Heritage Council

RE: MP 10_0171 330 Church Street Parramatta – Mixed use residential, retail and commercial development.

02 LONG SECTION LOOKING NORTH
1:200 @A1

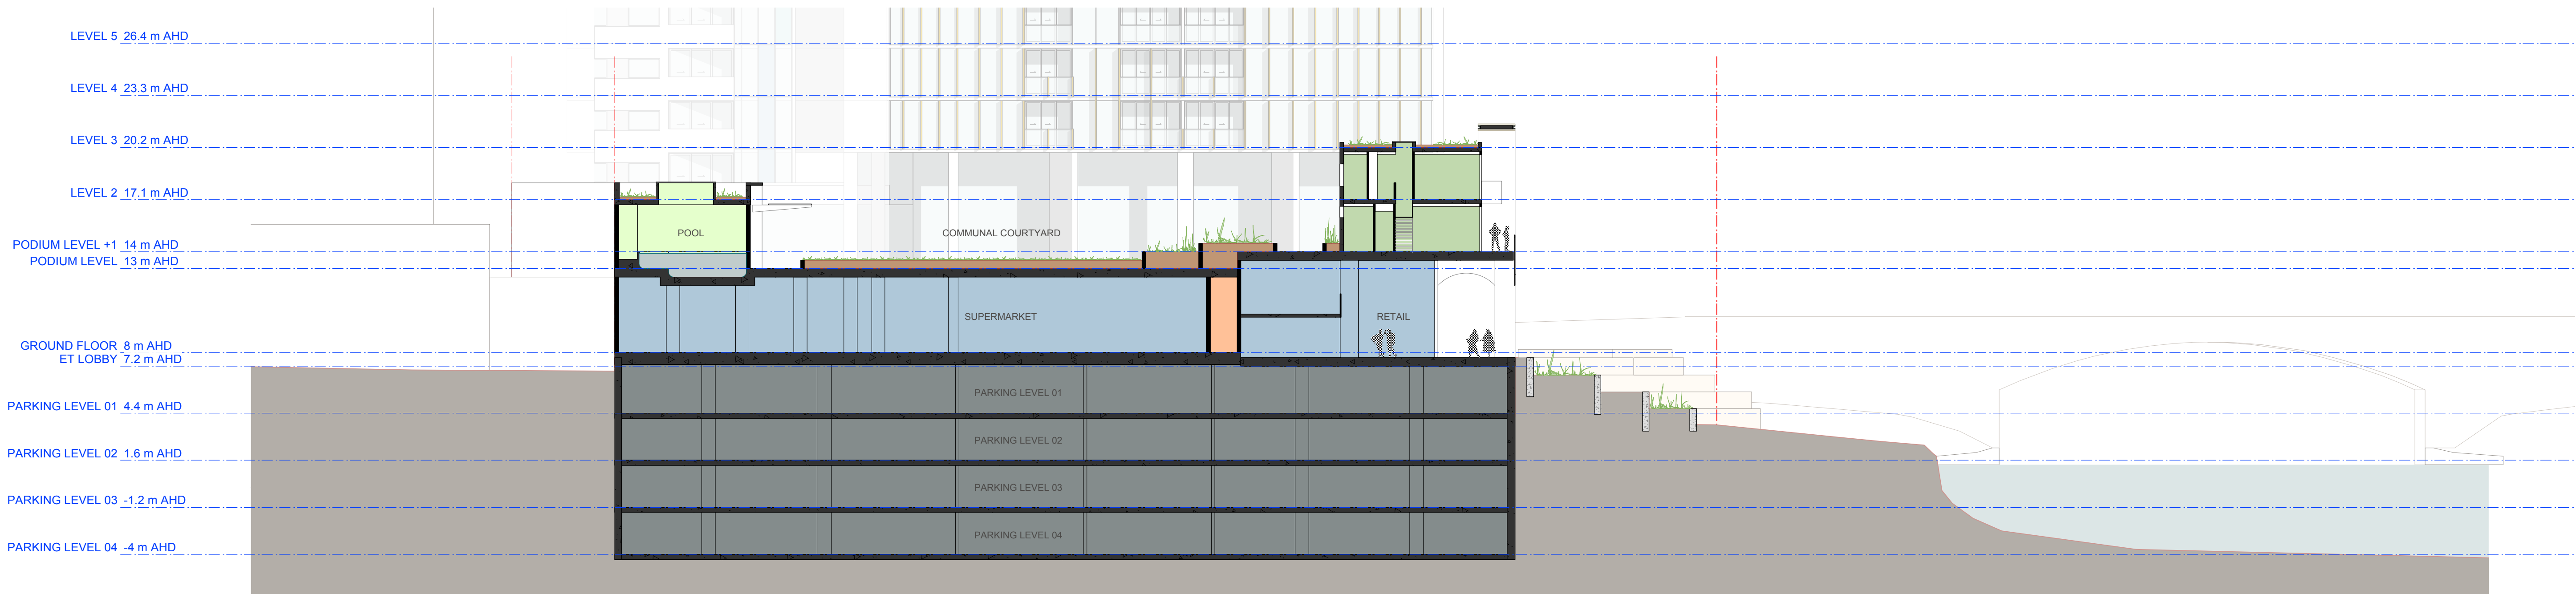
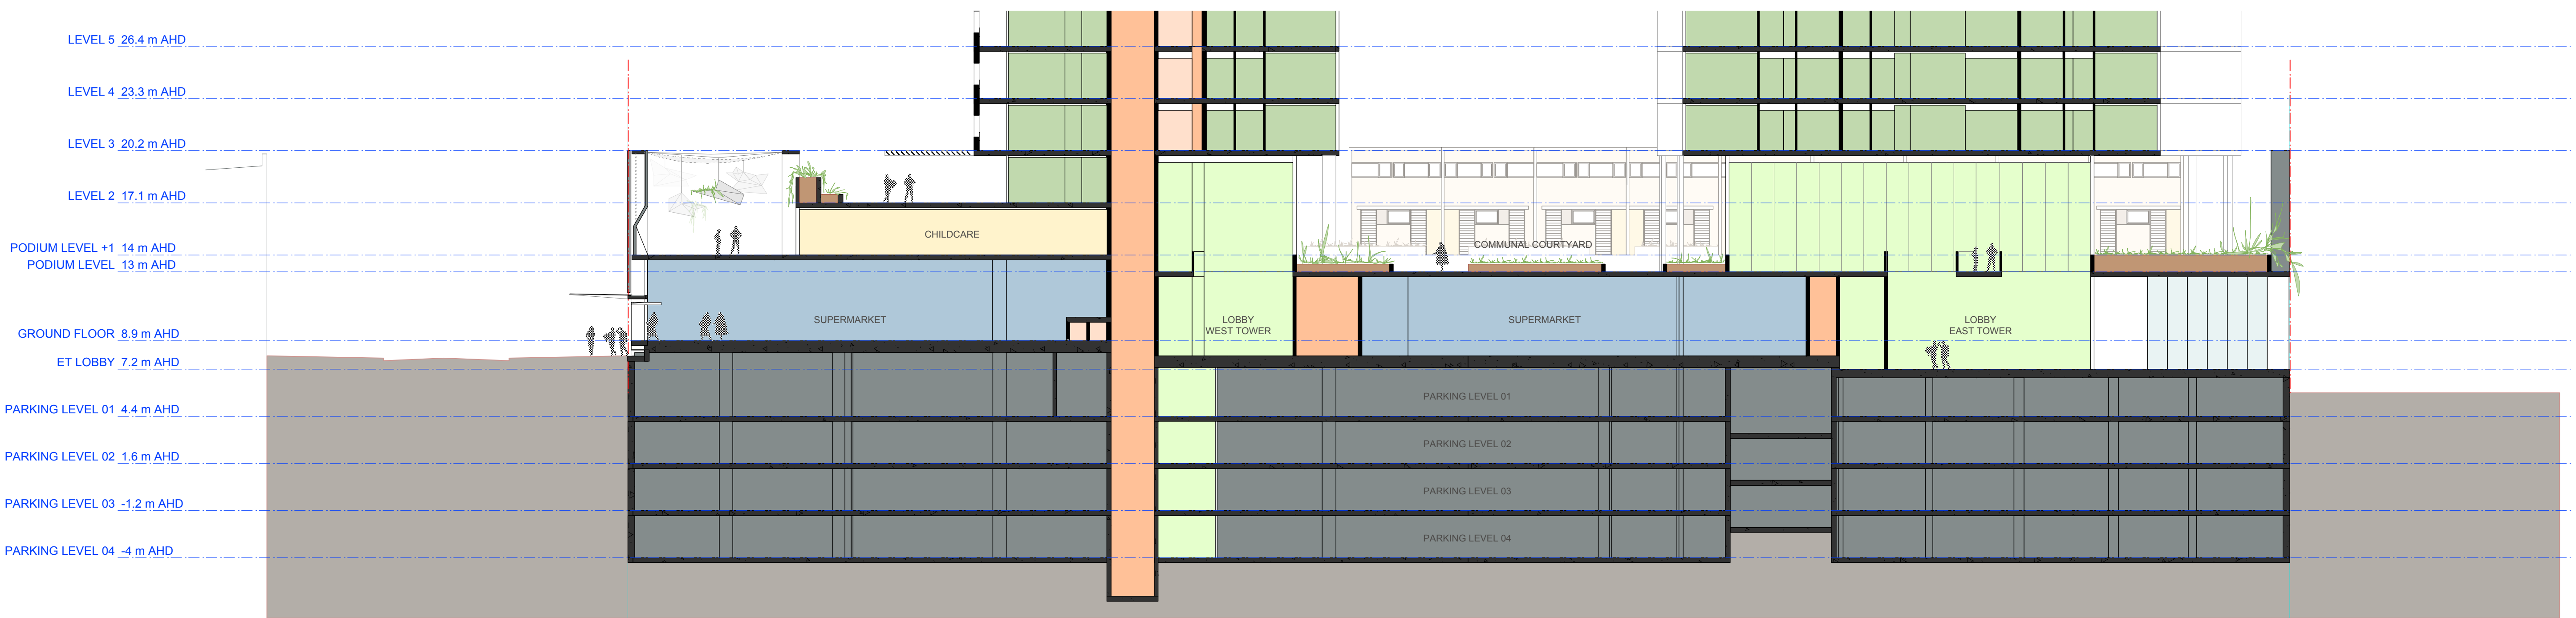
significant item and on its setting. The subject proposal is in substantial breach of the existing Local Environmental Plan's 90m height limit on this block. This height limit is directly due to the need to maintain the visual setting of Parramatta Park as a centre of colonial administration. It also reflects a planning principle paramount in Sydney Regional Environmental Plan 28 – Parramatta 1999 seeking to place the tallest new development around the railway station, stepping heights down to the Parramatta River and heritage items. It is recommended that the applicant be required to provide justification for why this height limit should be breached, and provide a revised assessment of any likely impacts;

PHOTOMONTAGE PROPOSED BUILDING HEIGHTS

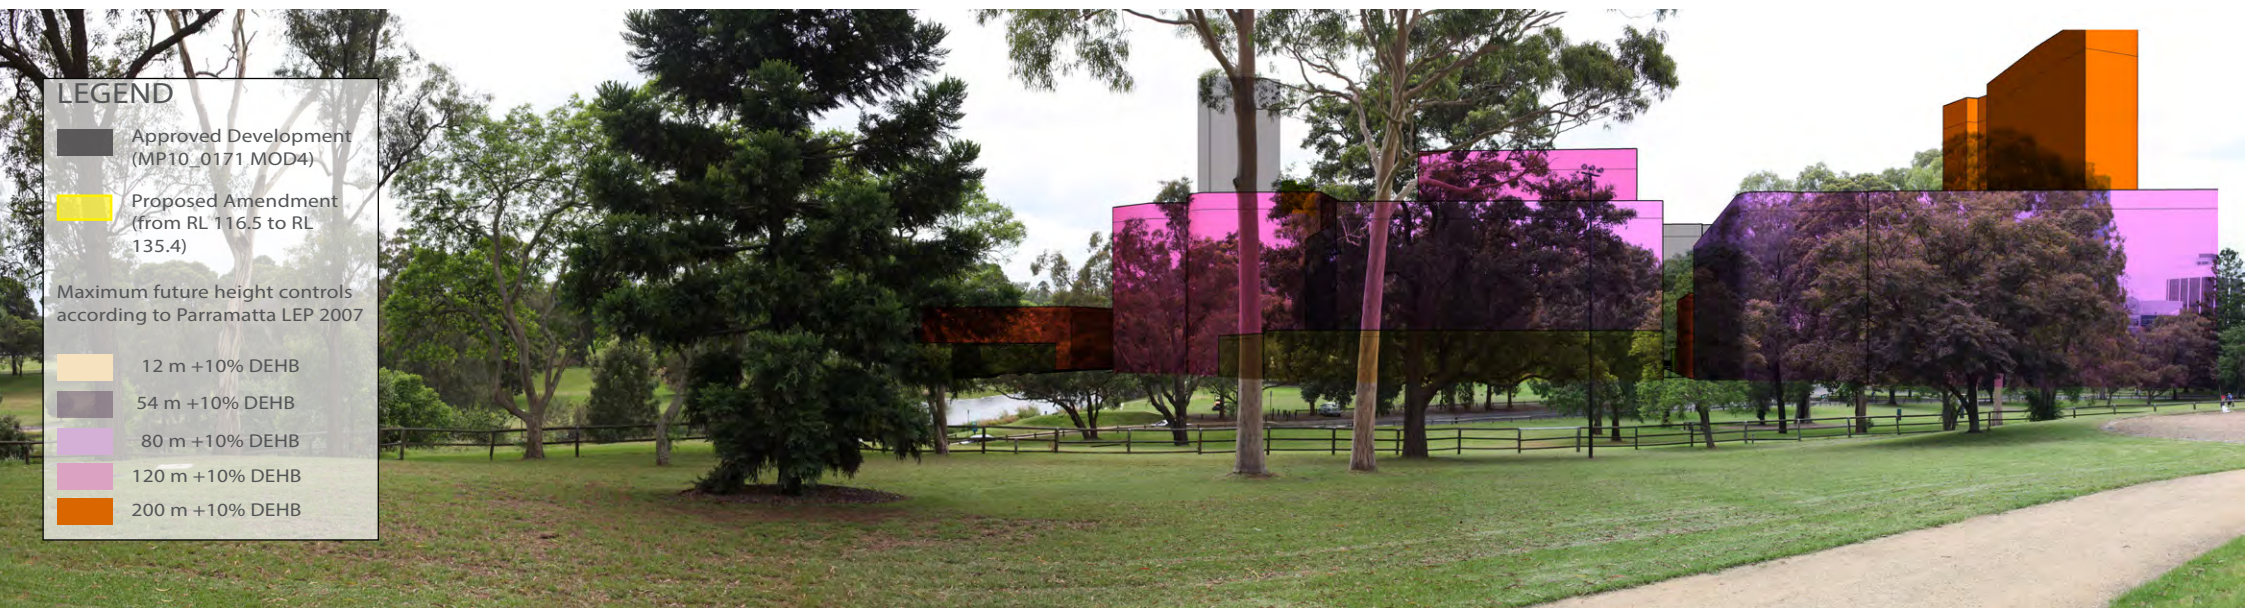
4. The subject development is in close proximity to a State, National and World Heritage Area (*Parramatta Park and Old Government House*, listed as part of a serial site listing called the *Australian Convict Sites*). It is noted that the Heritage Impact Statement submitted does not consider the impact of the proposed development on views from this
